Engineers Comments Regarding Surface Water Drainage Design

APPLICATION NO: Y/93/19/DOC

Site Address: Normandie Church Lane Yapton BN18 0EH

Description of Works: Approval of details reserved by condition imposed under ref Y/47/19/HH relating to Condition No 4 - proposed surface water drainage.

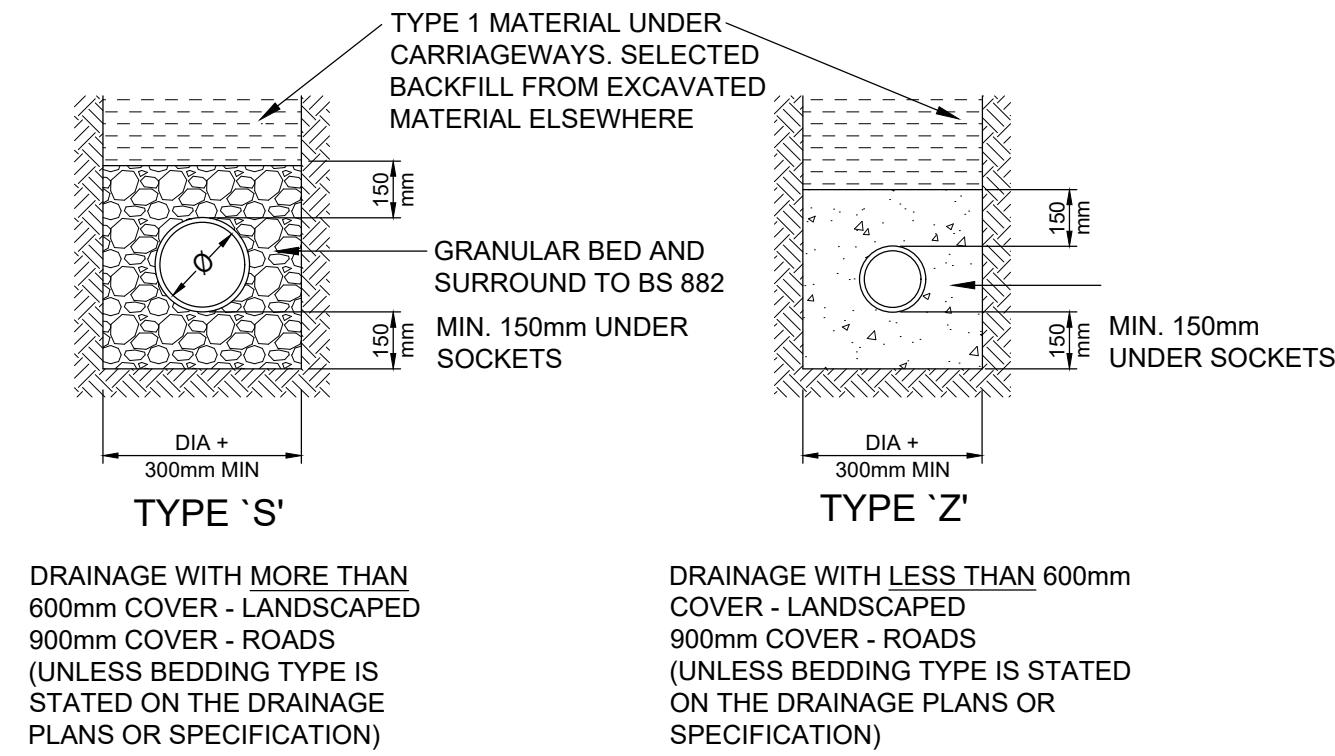
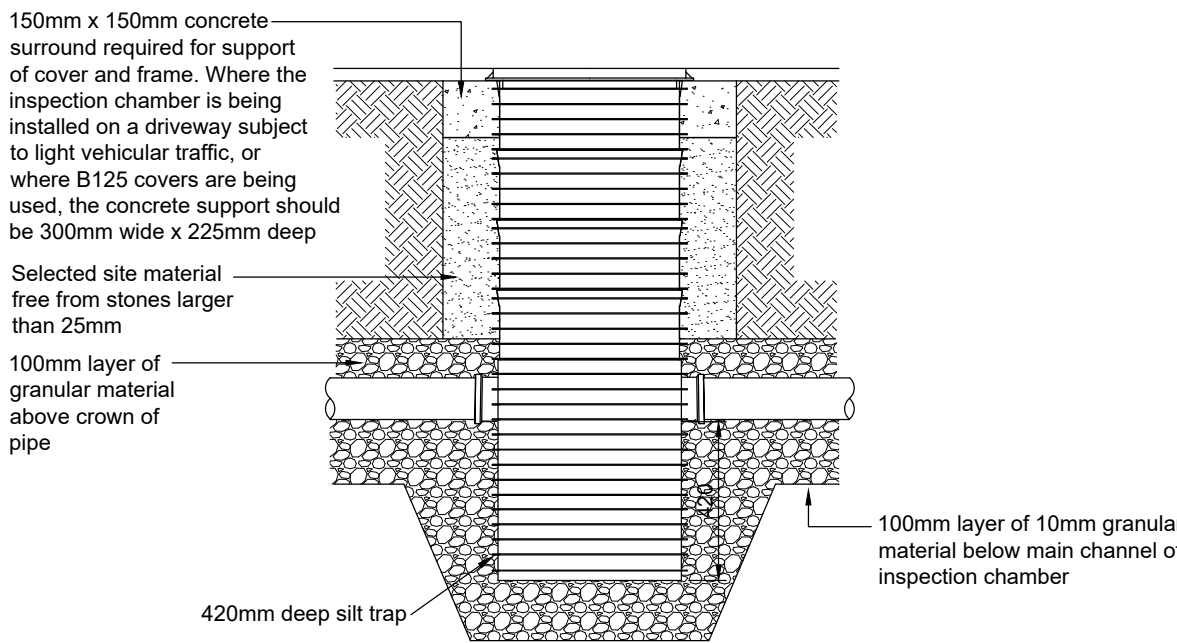
1. What were the exact dates of both the infiltration and groundwater testing?
2. What was the duration of the groundwater testing – how long was the trial hole monitored for?
3. For future reference, the trial pit dug for the infiltration testing is too small and not in accordance with BRE 365. Guidance states that the pit should be 0.3-1m by 1-3m in area.
4. Please use Ratio-R value of 0.35 in your calculations.
5. Please provide calculations for the 1 in 100year +40% event half drain time.
6. The pipe must not go into the base of the soakaway, it should be at the top of the crates. Please adjust drawing and levels to reflect this.
7. Please label cover levels at rainwater pipes and/or the falls to the silt trap.
8. Please make it clear on the drawing that S1 is a silt trap and clarify whether it is a 450 or 460 diameter. (Plan drawing and detail are labelled differently.)
